From: Laura Gibbons
Sent: 11 February 2019 14:19
To: 'Nia Russell'; David Omonitan
Cc: Mr Will Marsh; Arfon Hughes; Steve hawkins; Katelyn Naidoo; Michael Eastham
Subject: RE: Planning Consultation on: BE/135/18/PL

Engineers Comments Regarding Surface Water Drainage

APPLICATION NO: BE/135/18/PL

Site Address: Salt Box Field Land off Rowan Way Bognor Regis PO22 9NW

Client: LANDLINK ESTATES
Architect: MOUNTFORD PIGOTT
Project: SALTBOX SITE BOGNOR REGIS
Drawing Title: PHASE 1 DRAINAGE STRATEGY PLANNING SHET 2 OF 3

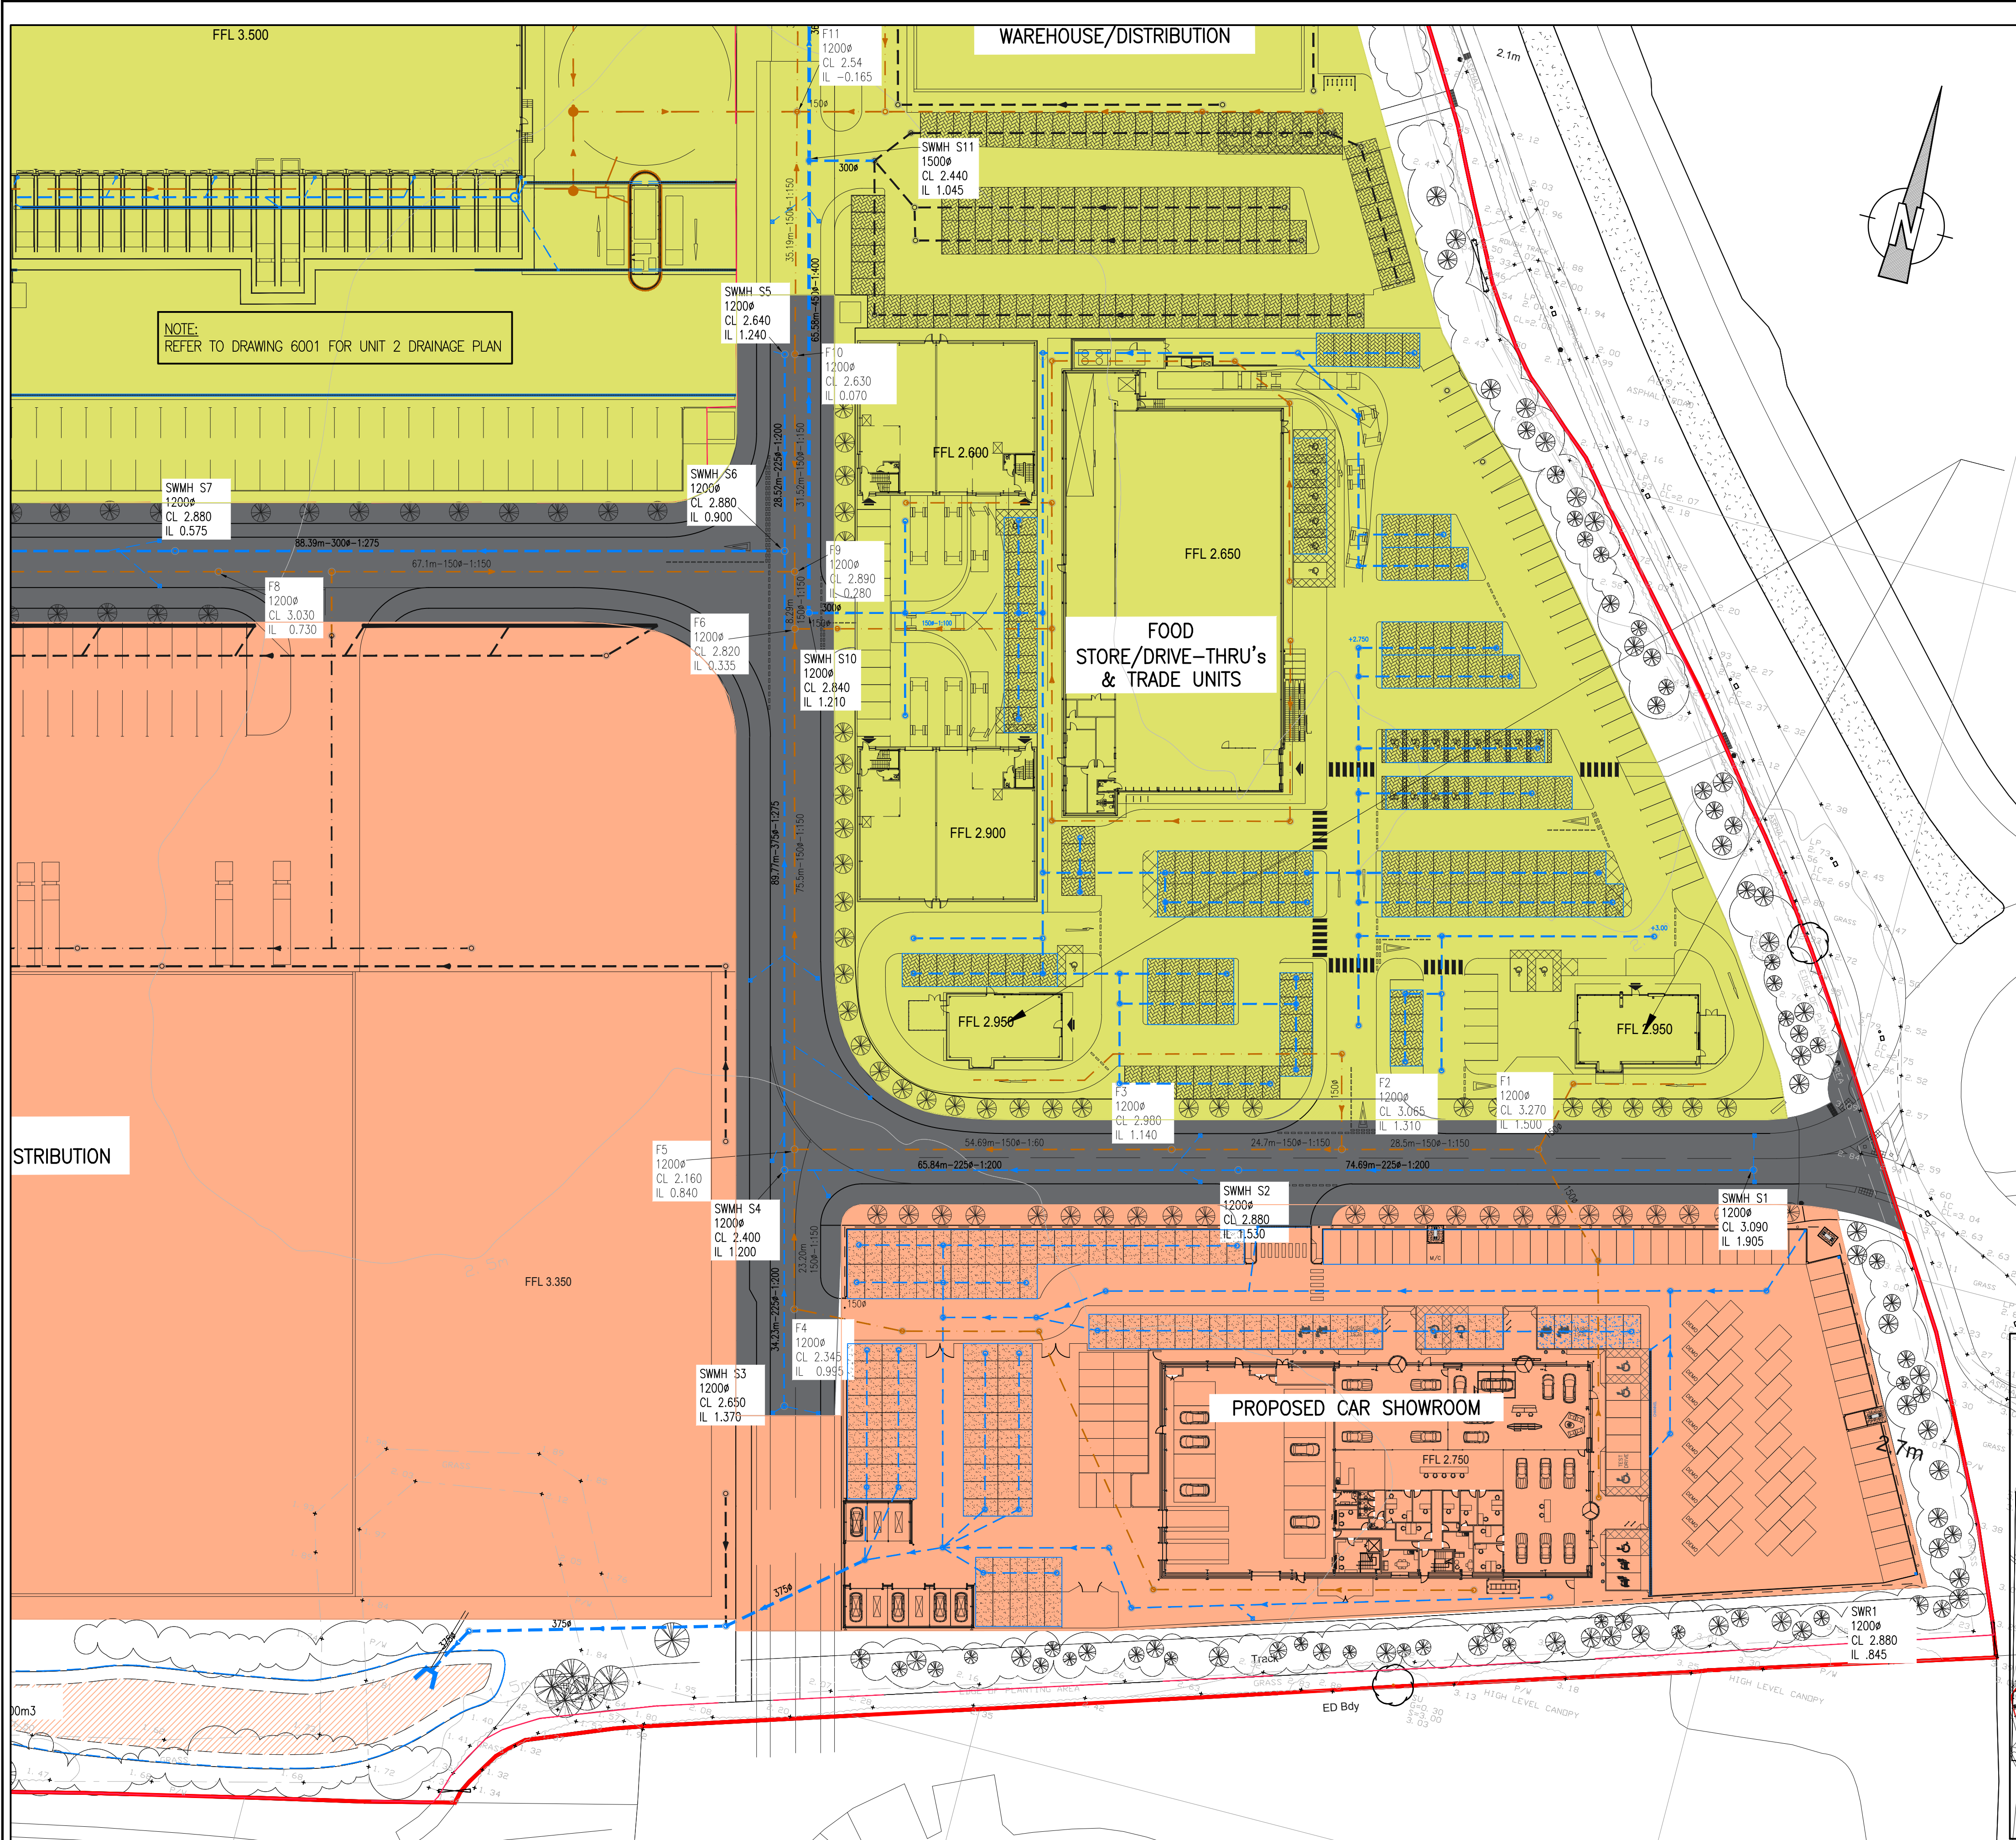
Therefore, I again request that you complete shallow infiltration testing at depths associated with permeable paving.

It appears that only two infiltration test locations were used on this large site. One of these test pits gave results which do not prevent infiltration from being used. More infiltration tests must be completed, and some should be completed at shallower depths to determine if the use of permeable paving is appropriate.

The proposals currently show that attenuation and controlled discharge to watercourse (both main river and ordinary watercourse) are proposed. No evidence has been submitted to demonstrate that infiltration is not viable.

Infiltration must be investigated.

Infiltration tests were carried out back in November of 2017 in five different locations (see figure 2 of the Site investigation report of 03/01/2018 by EPS) scattered around the developments, infiltration rates vary from 1×10^{-6} to 5.78×10^{-7} m/s (see page 15 of EPS report).

The report concluded that the infiltration rates recorded are very low to practicably impermeable soils, this suggest the presence of clay and groundwater.

Although ground water monitoring is still on going, both the site investigation reports provided by EPS in January 2018 and updated in anuary 2019 do no not recommend infiltration SuDs for the drainage proposal.
